**FROM: Adam Charlton TO: Arun District Council
FAO: Mr D Easton**

SUBJECT: WA/58/15/HH - Vehicular crossover within the Walberton Conservation Area.

Frogs Leap, 1, Walberton Green, Walberton, BN18 0AT

DRAWING NO. FL - 003

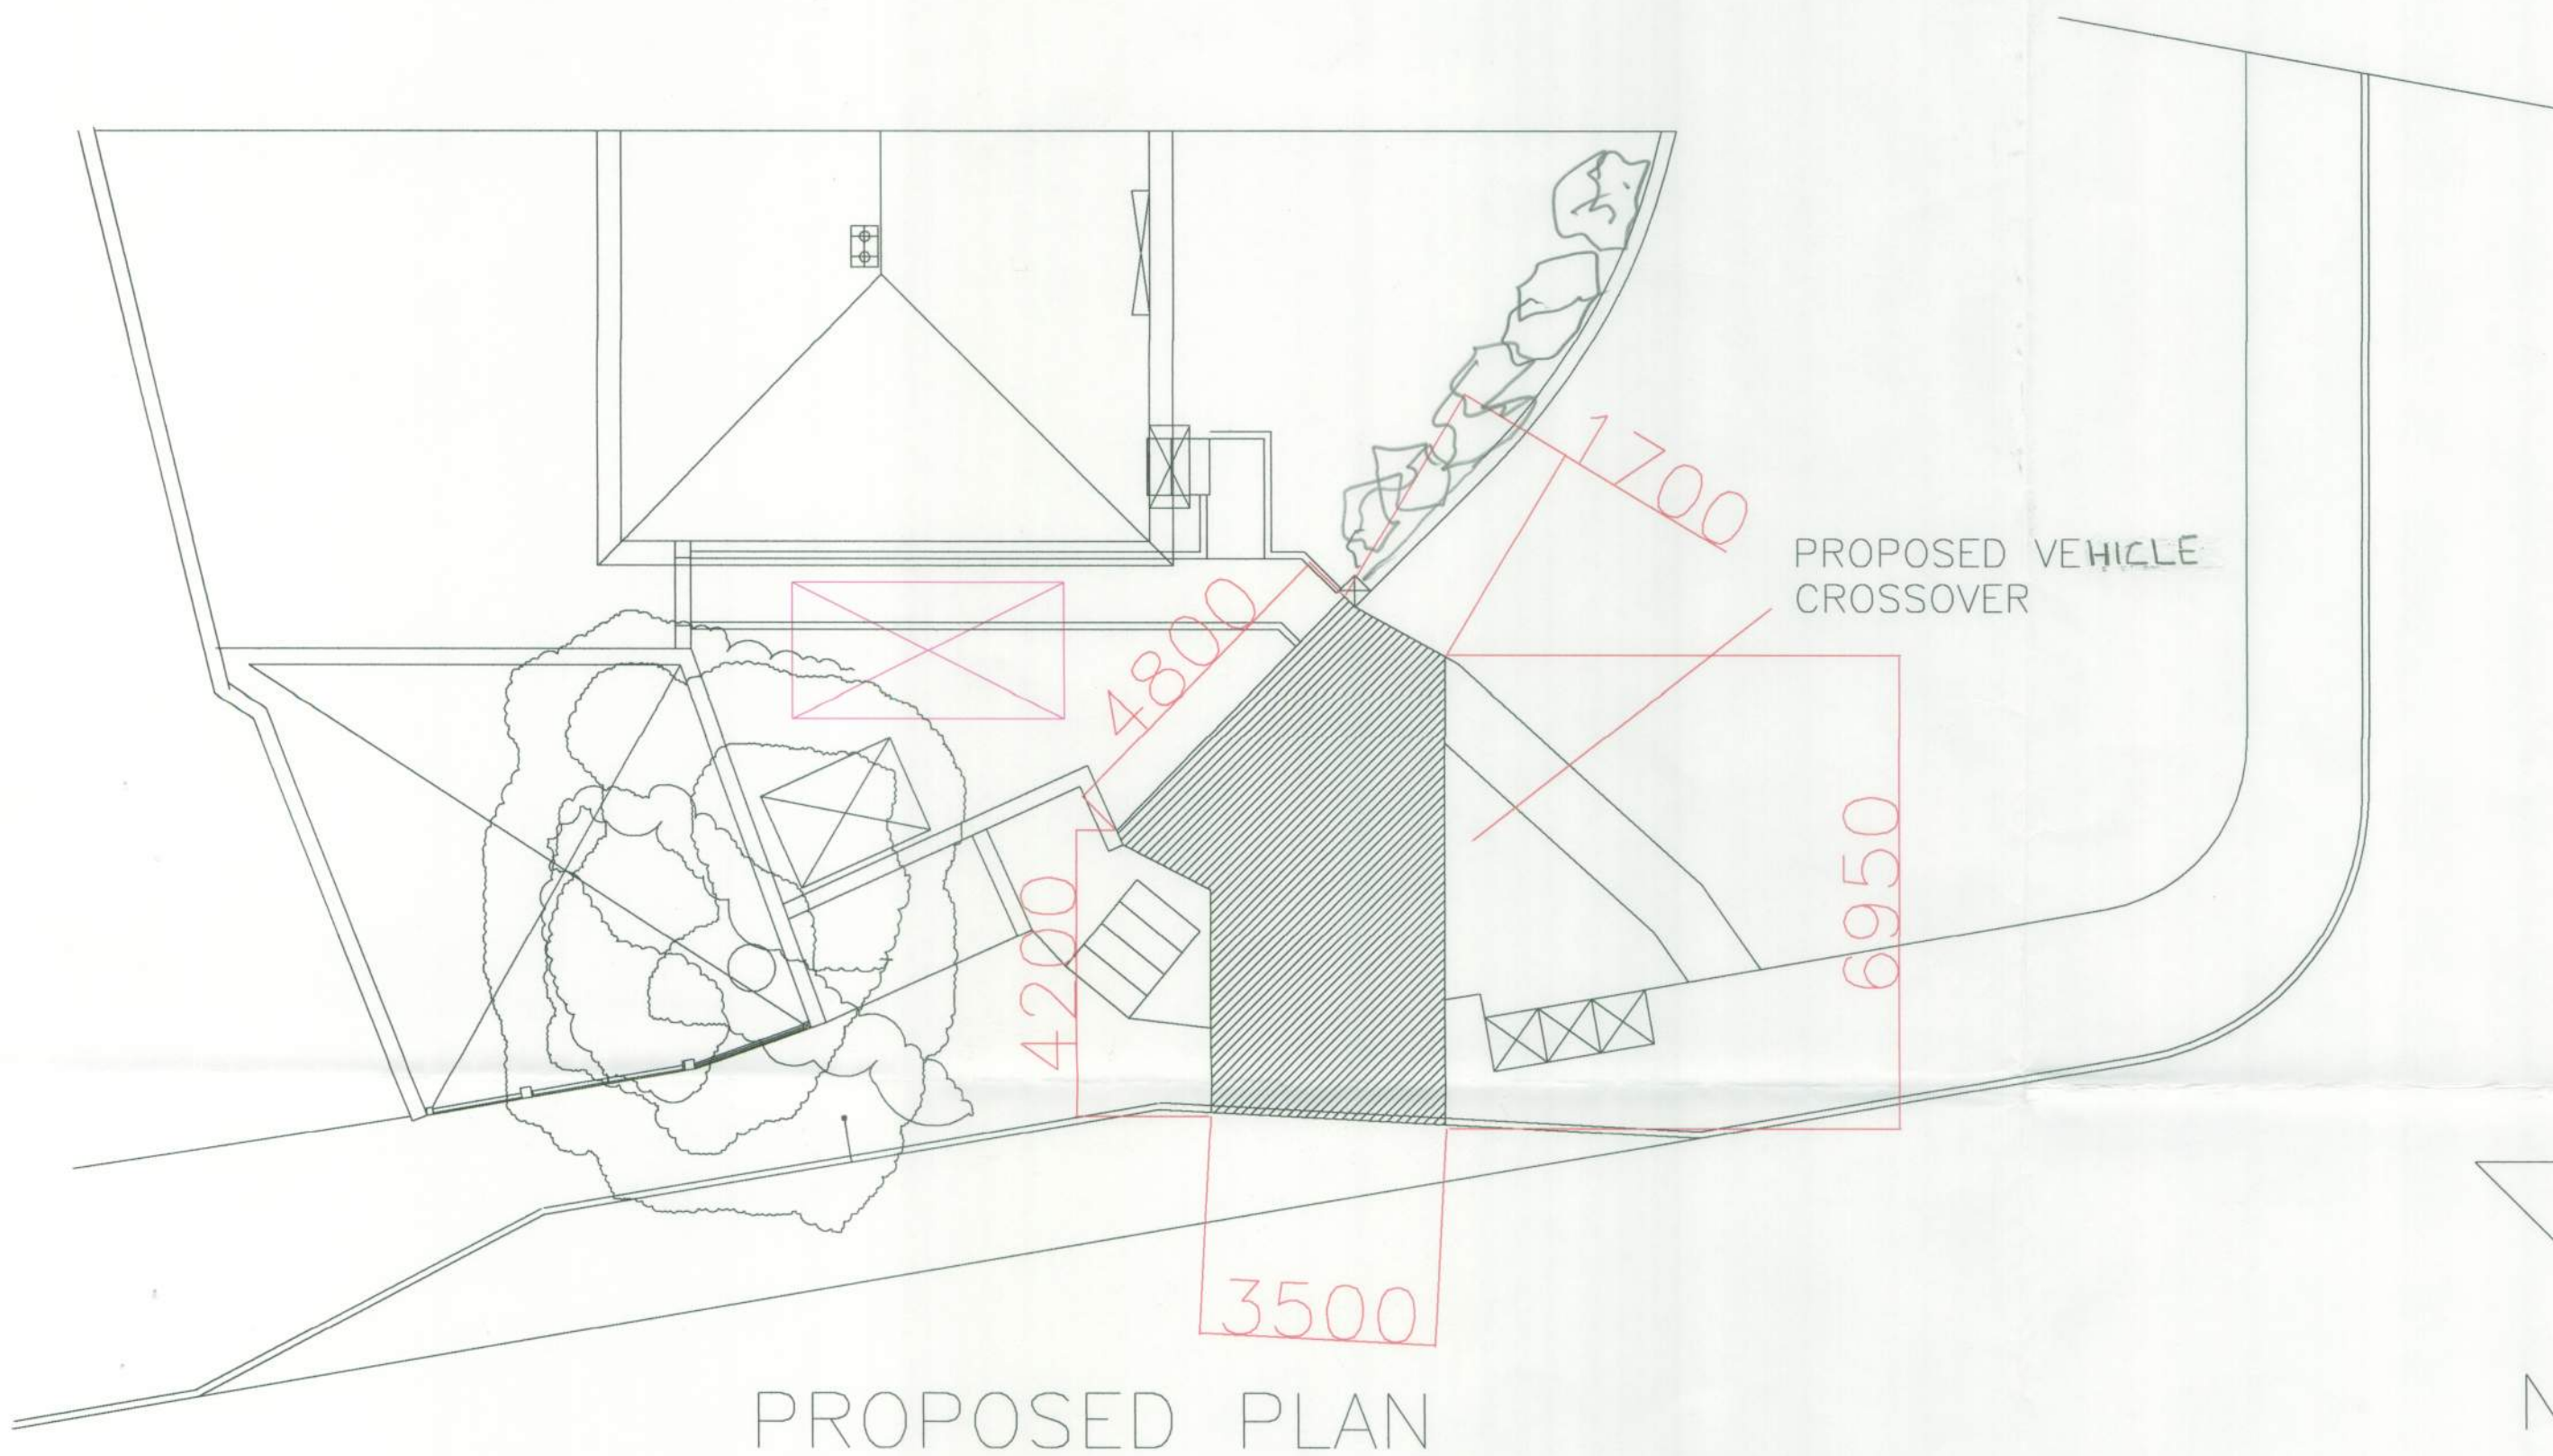
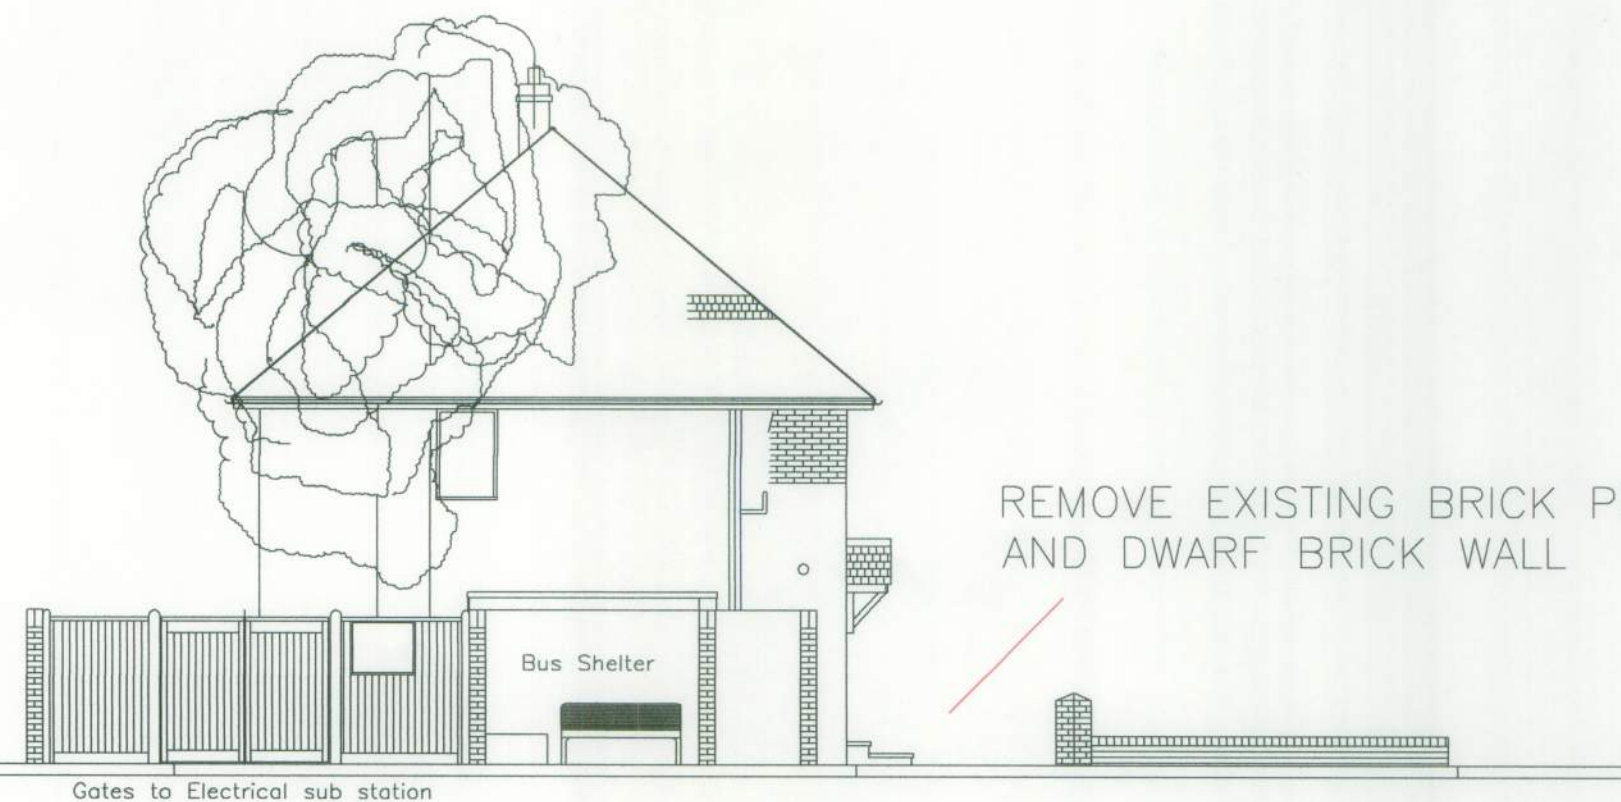
The proposal is for a vehicular crossover with access onto The Street.

From an inspection of the plans alone, there is no apparent visibility issue at the point of access onto The Street. The applicants have entered into a dialogue with WSCC as the licencing authority for the crossover, to which advice was given as to an appropriate access point through the bus layby. It should also be noted that the crossover does not incur into land that has been designated as village green.

PROPOSED VEHICLE CROSS OVER AT FROGS LEAP, WALBERTON GREEN FOR MRS. L COLLINS
SCALE 1:200
DATE 18-09-2015
DRAWING NO. FL — 001 — A

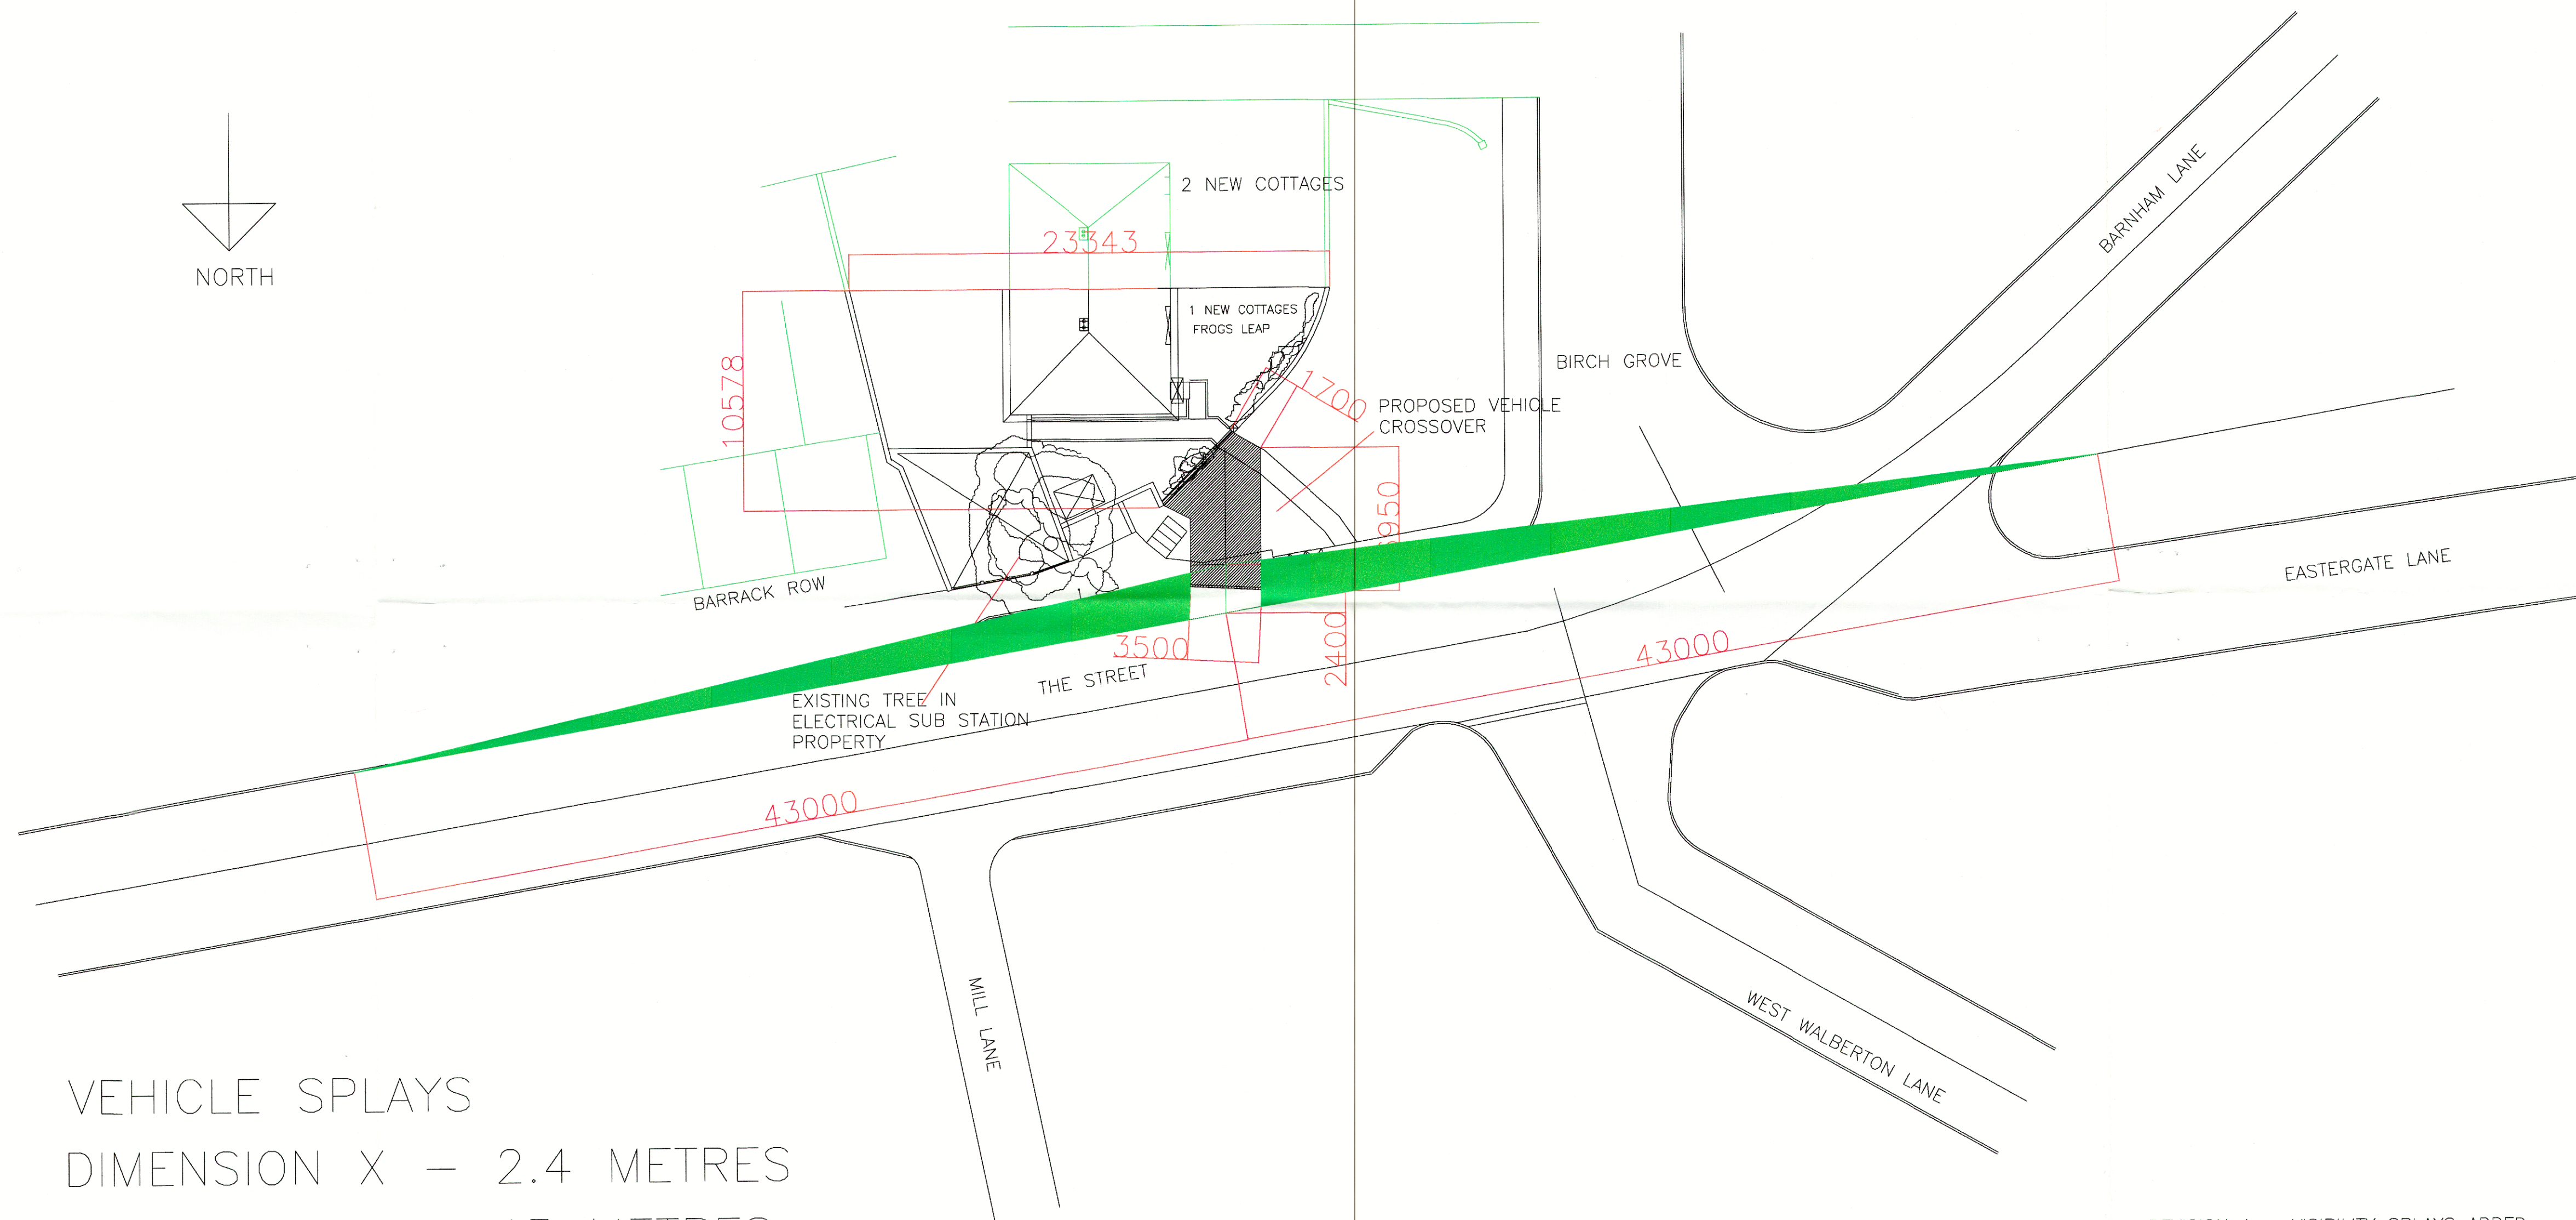
No part of the development shall be first occupied until visibility splays of 2.4 metres by 43 metres have been provided at the proposed site vehicular access onto The Street in accordance with the approved planning drawings. Once provided the splays shall thereafter be maintained and kept free of all obstructions over a height of 0.6 metre above adjoining carriageway level or as otherwise agreed.
